Re: Coors / Montano Trailhead, Grading and Drainage Plan
Engineer's Stamp dated 12-15-03 (E12/D19)

**Re: City Trailhead Parking (Learning Rd.) Cncp. Grading and Drainage Plan
Engineer's Stamp dated 12-17-02 (E12/D19)**

sheet title
GRADING & DRAINAGE PLAN

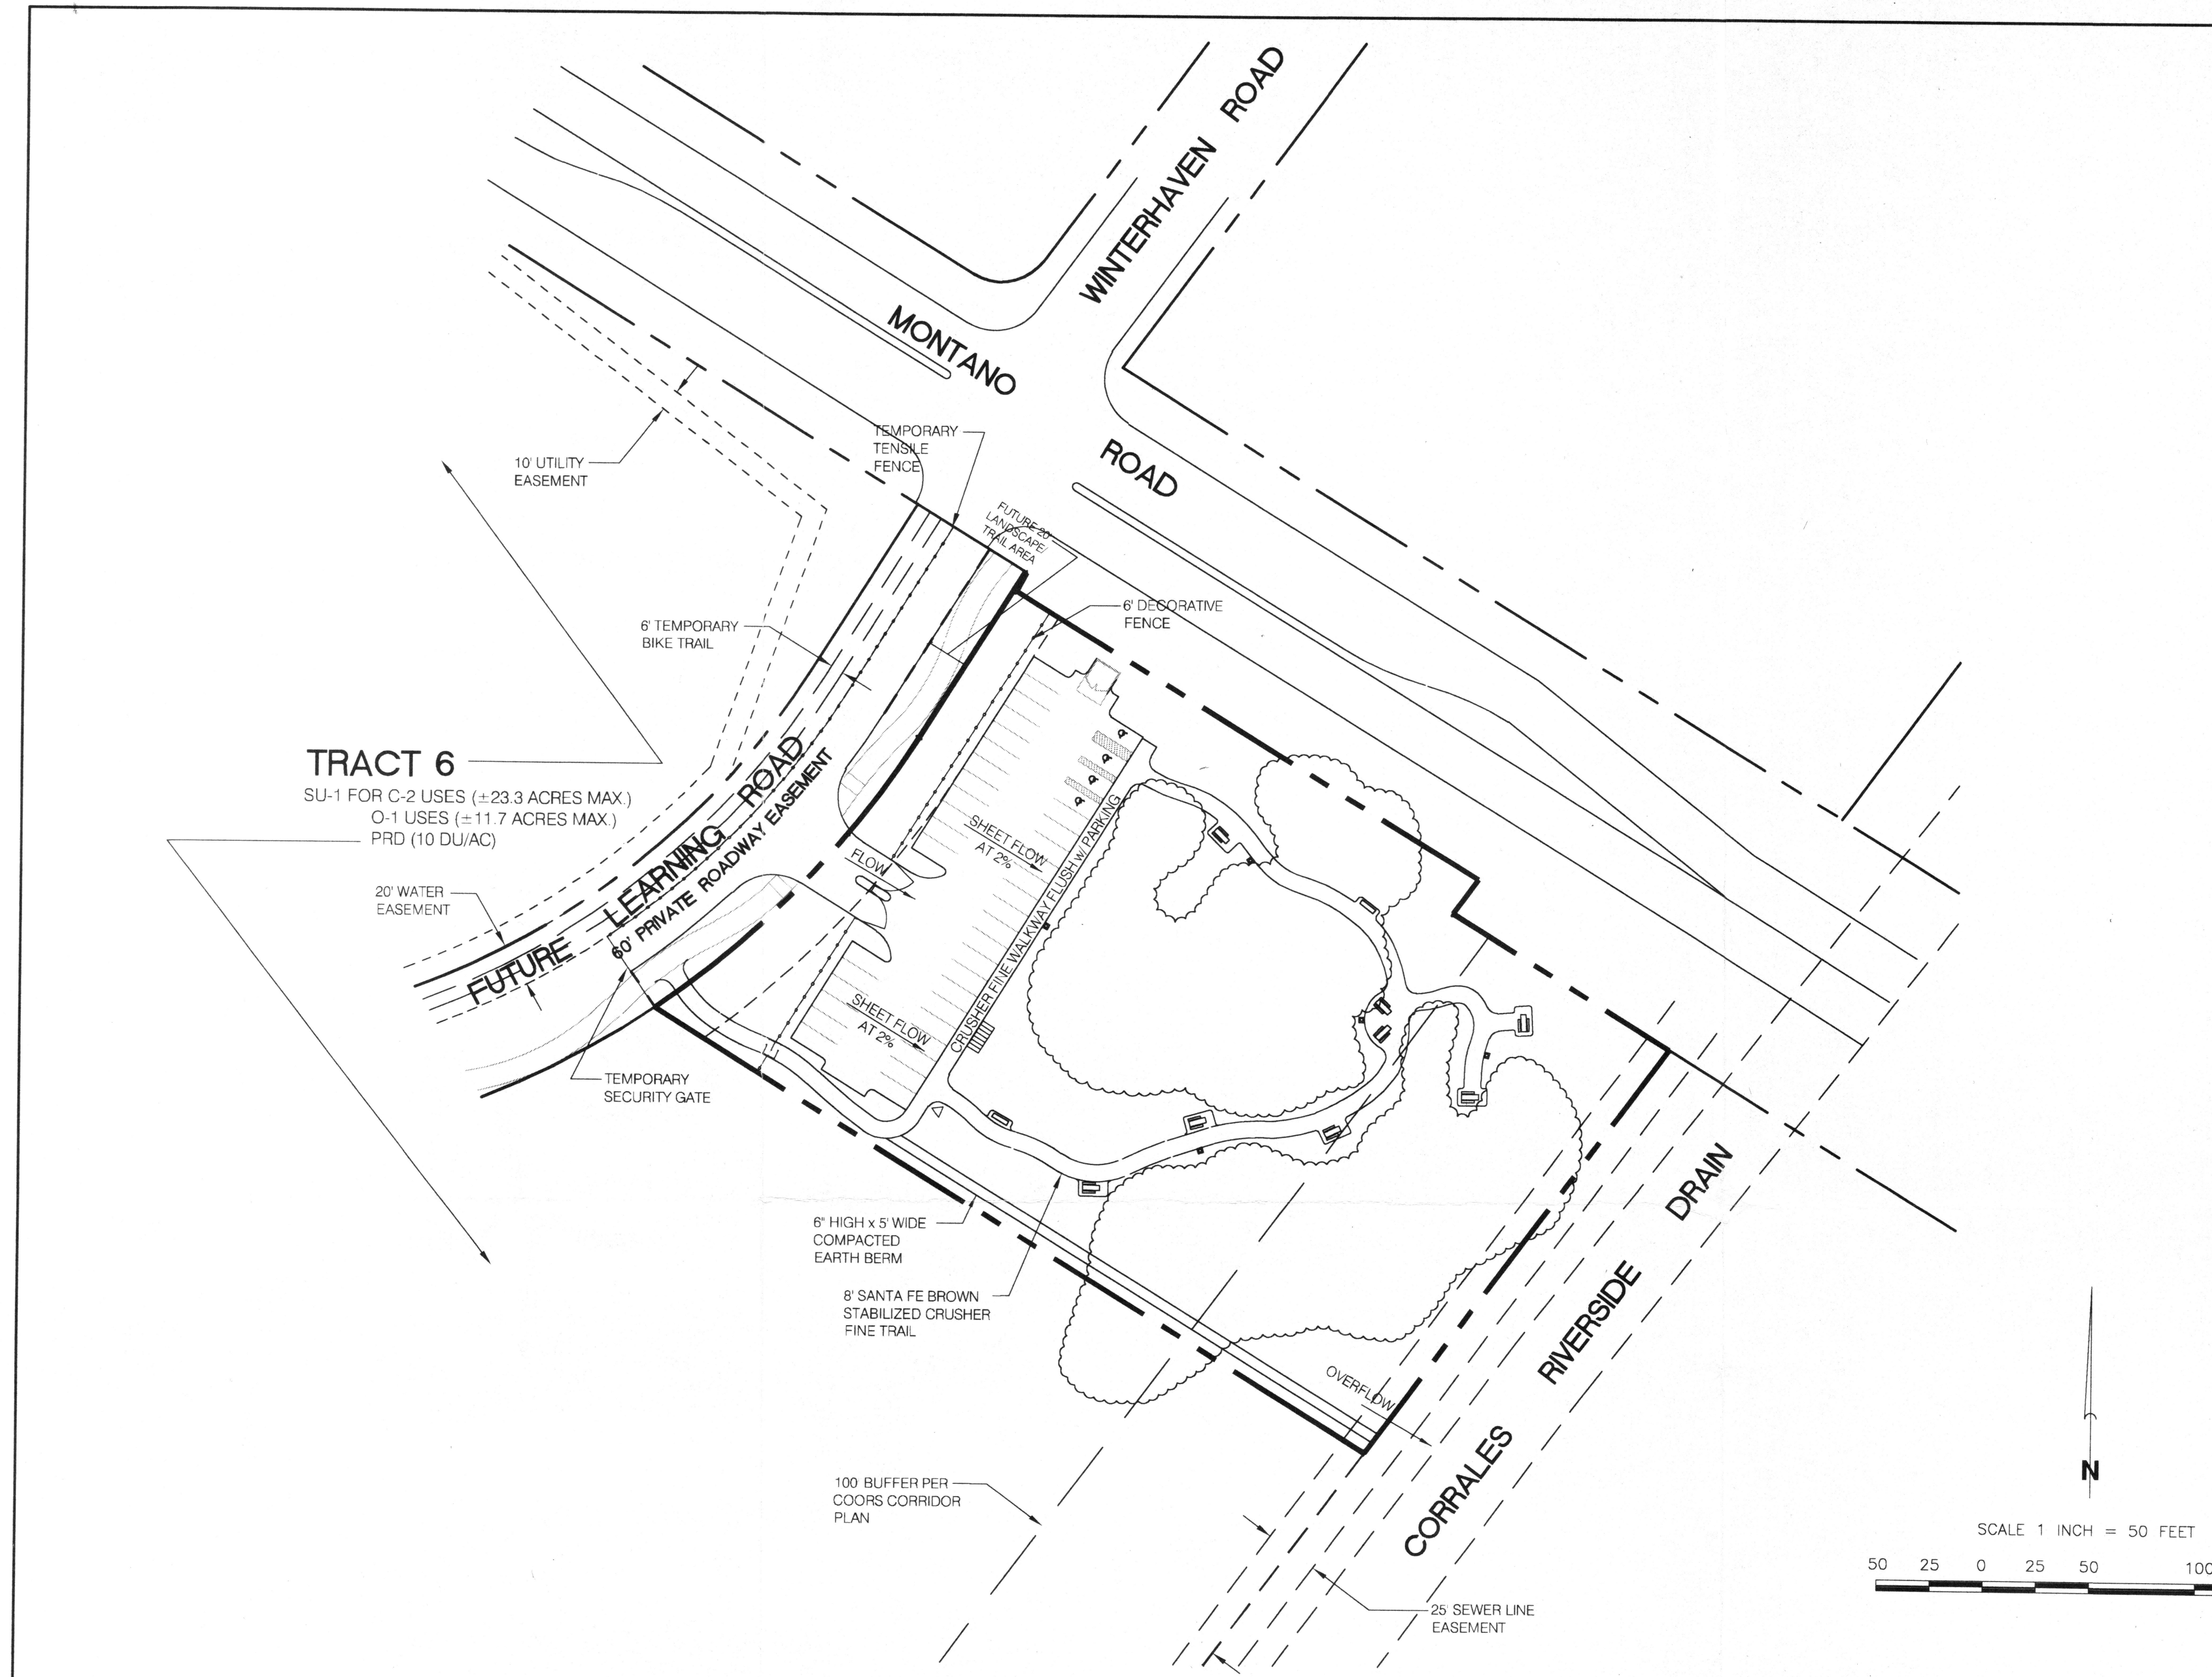
Based upon the information provided in your submittal dated 12-19-02, the above referenced plan is approved for Site Development Plan for Subdivision action by the DRB. Prior to Work Order, please submit a more comprehensive plan that can be constructed. Include a profile of Learning Rd. and grades along Montano. It would be prudent to include data about the master plan also, since it is Hydrology's policy to have all plans submitted be able to stand on their own merit.
